Brackley Investments Ltd
6 Lower Farm Barns
Bucknell
OX29 6ZD

Our Ref: CM/22/21/NMA

Non-material amendment following the grant of CM/16/18/PL (APP/C3810/W/19/3227374) for:

Bairds Farm Shop, Field Rear Of Crookthorn Lane Climping BN17 5SN

Plant Enclosure

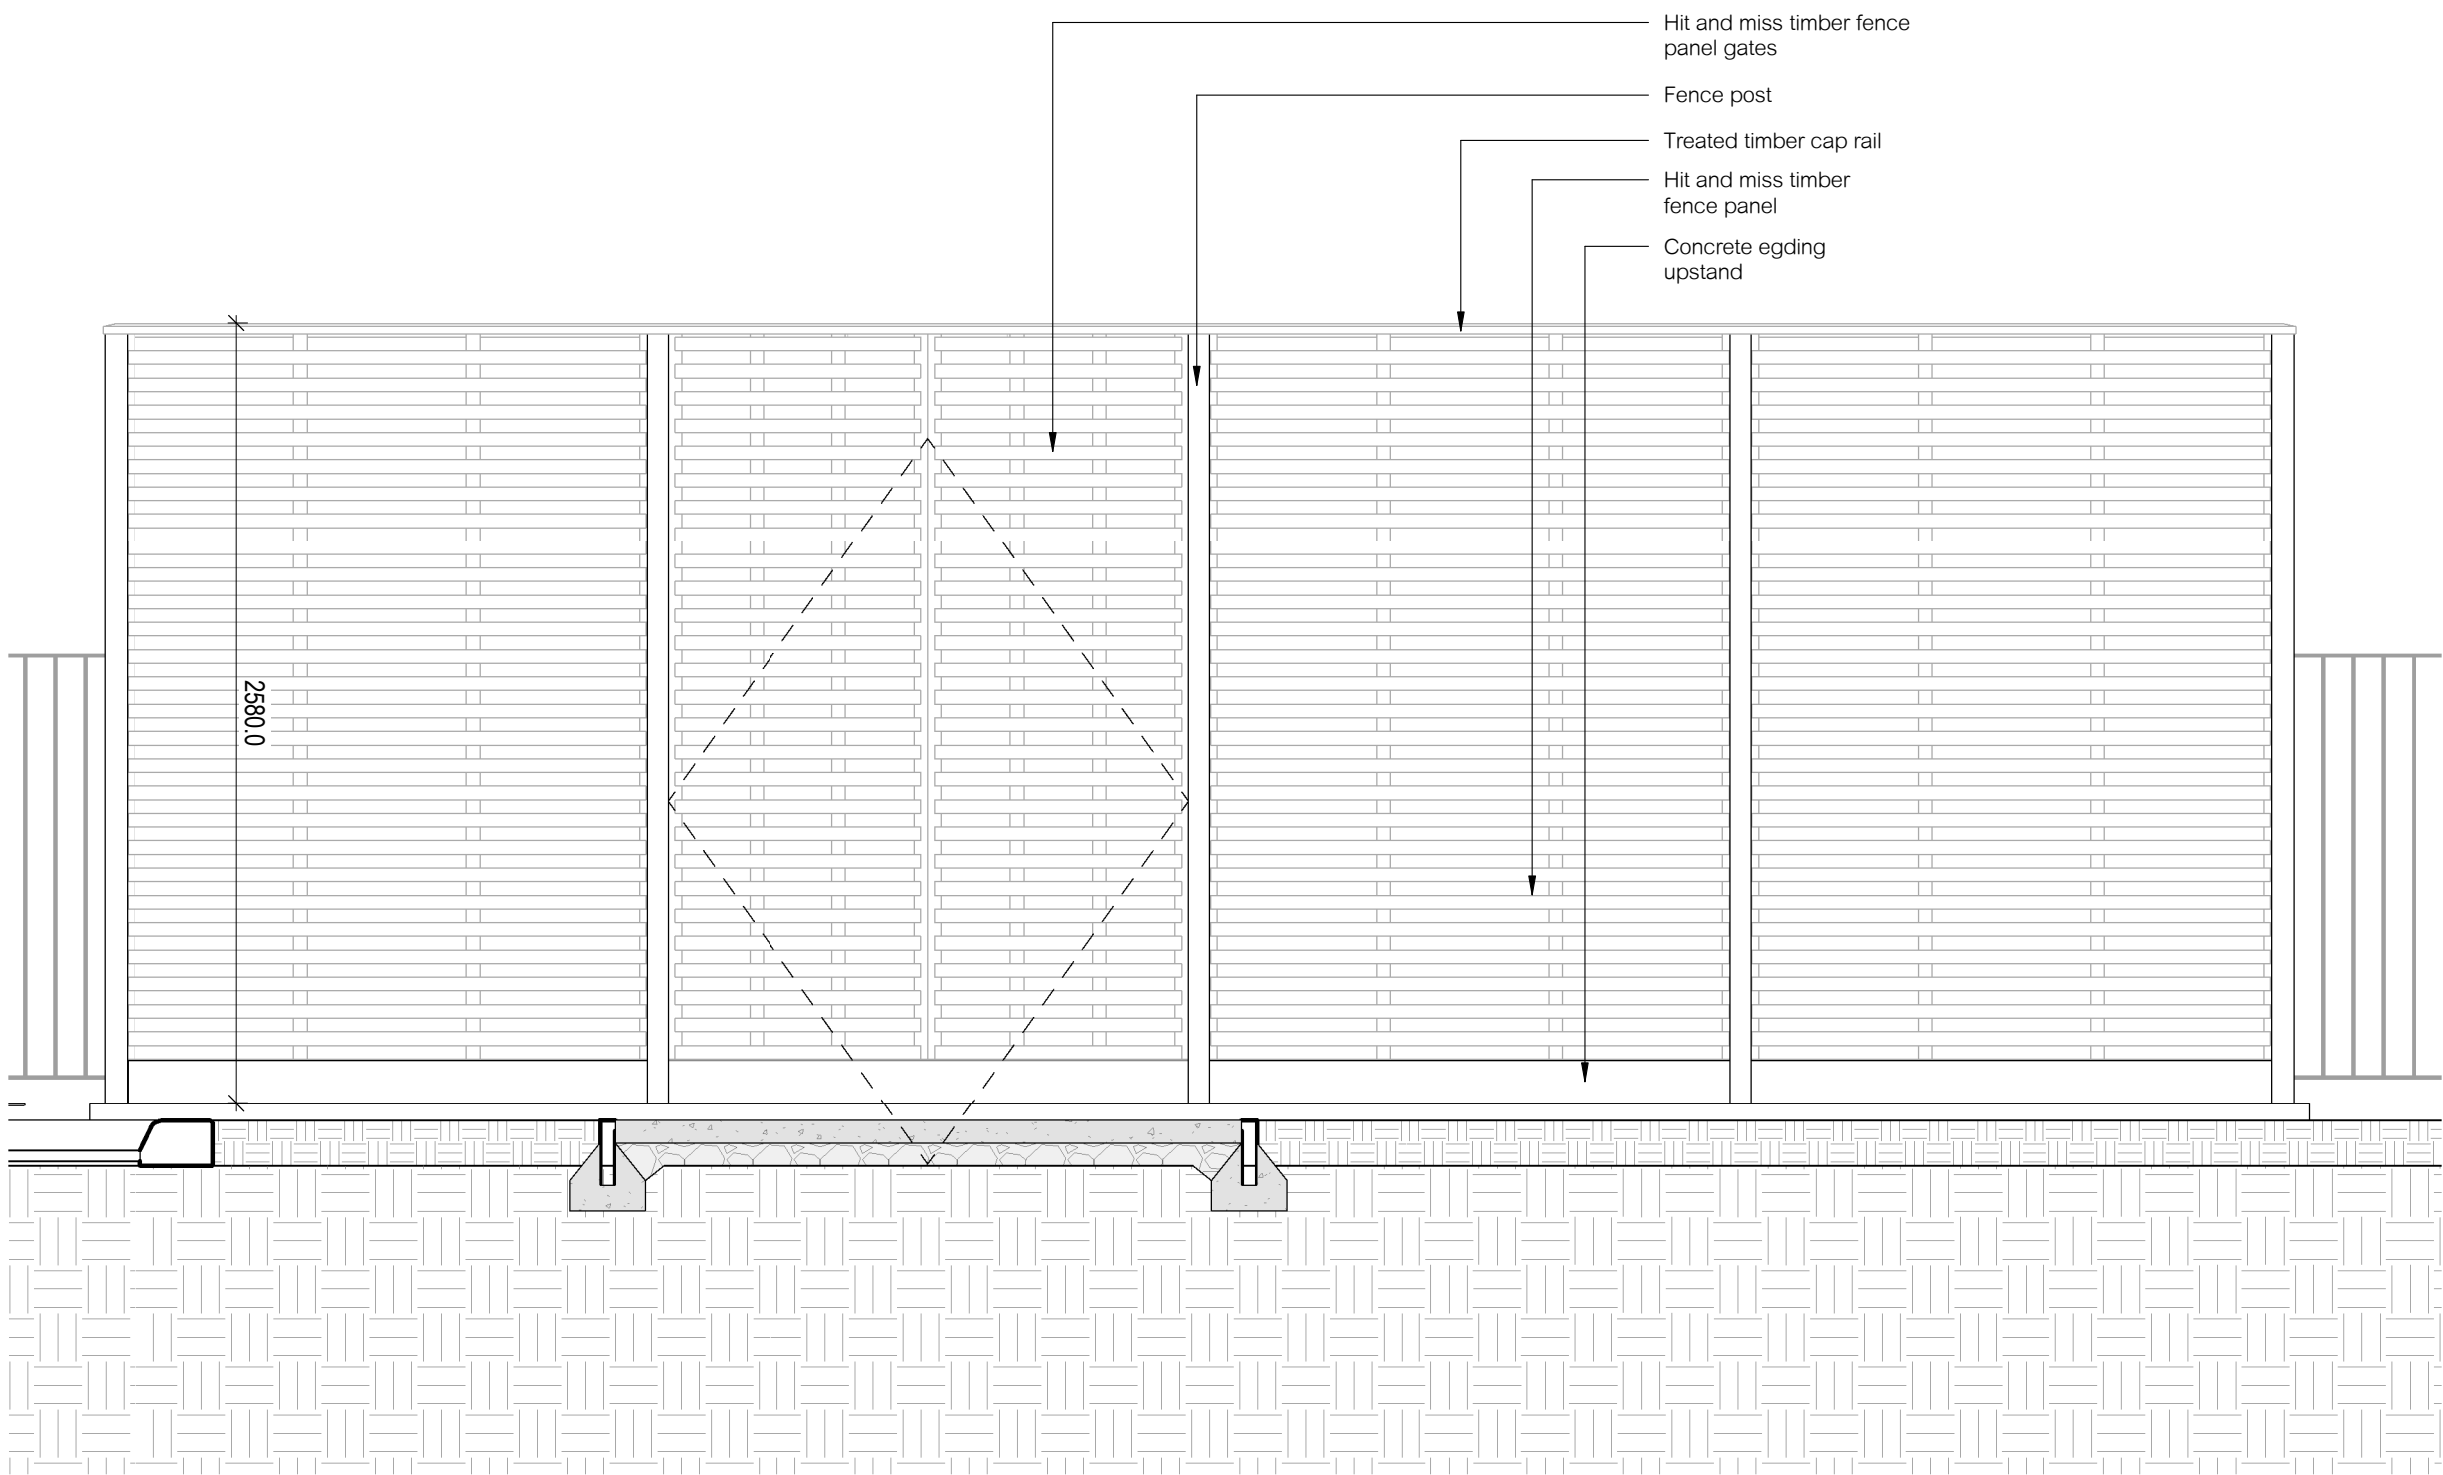
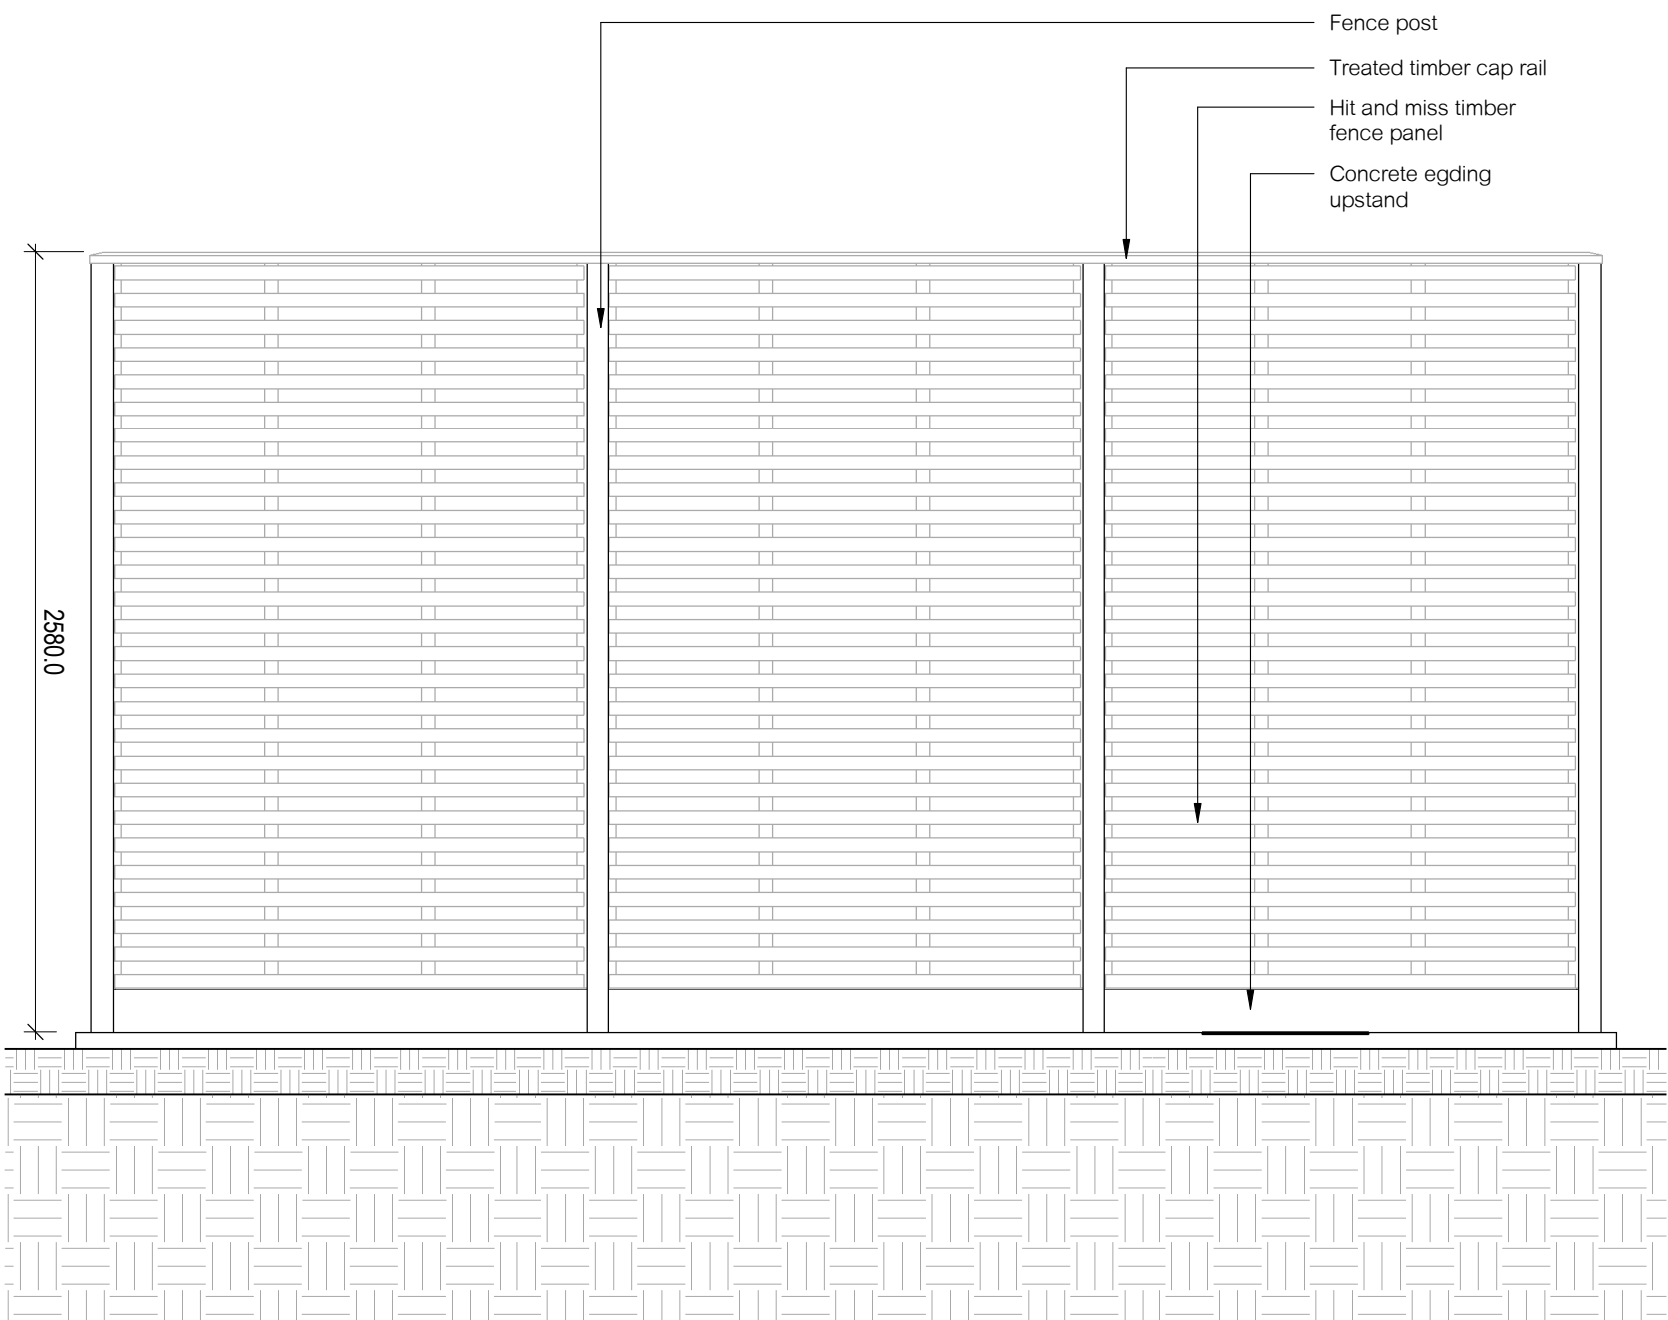
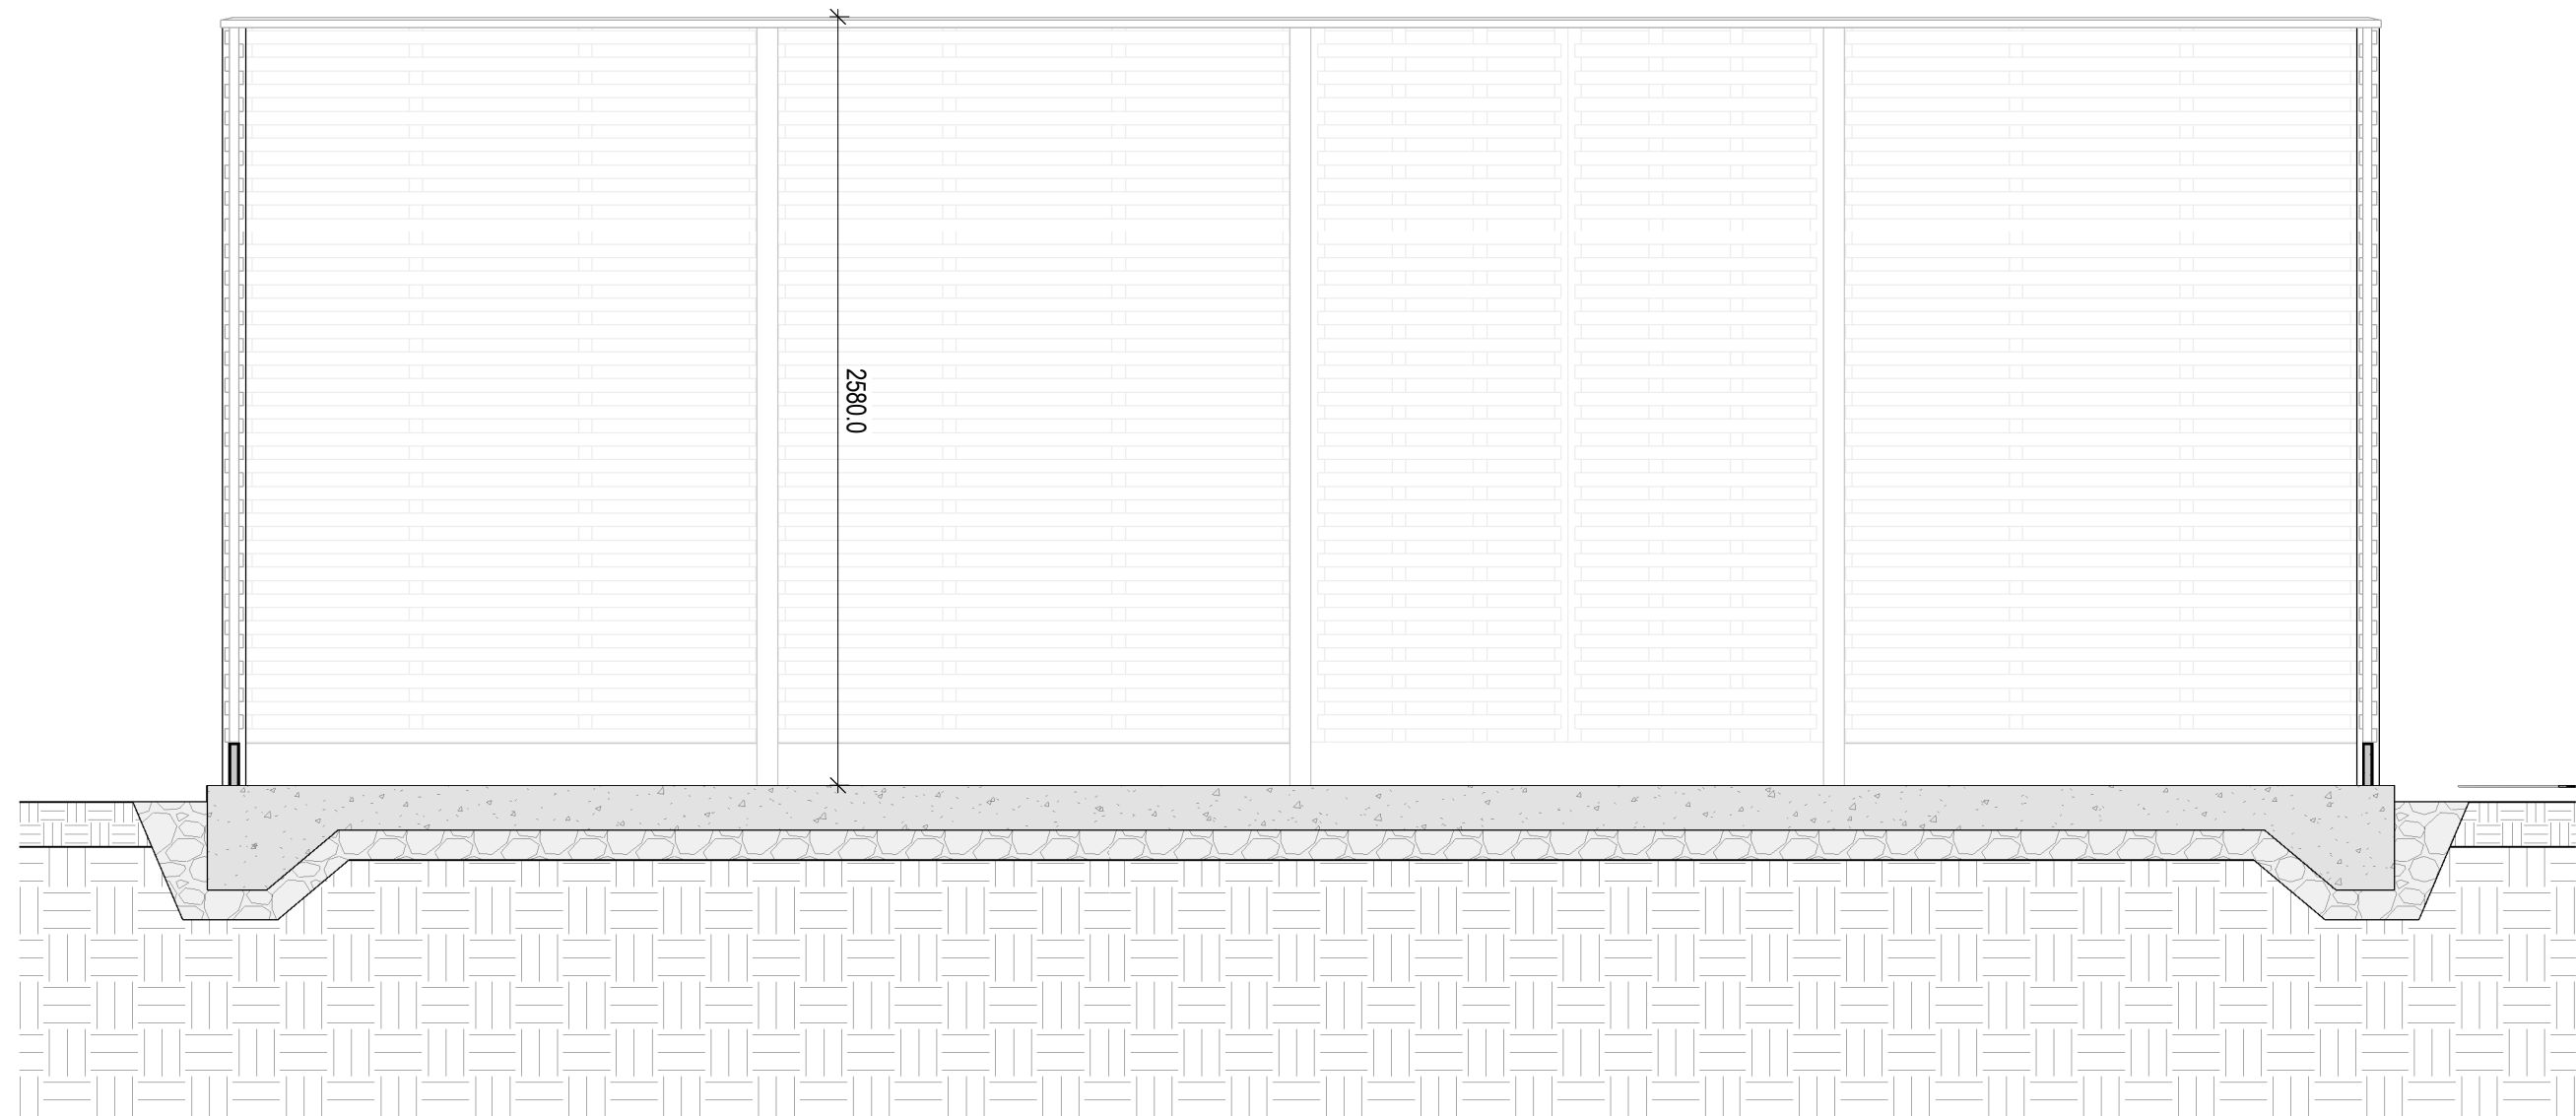
The reasons that these proposals have not been accepted as Non-Material Amendments is because the Installation of air source heat pumps within an associated enclosure together with a new electricity substation building would warrant re-consultation with Council departments and statutory bodies and

the structure is of significant size and cannot therefore be considered under section 96A of the Town and Country Planning Act 1990.
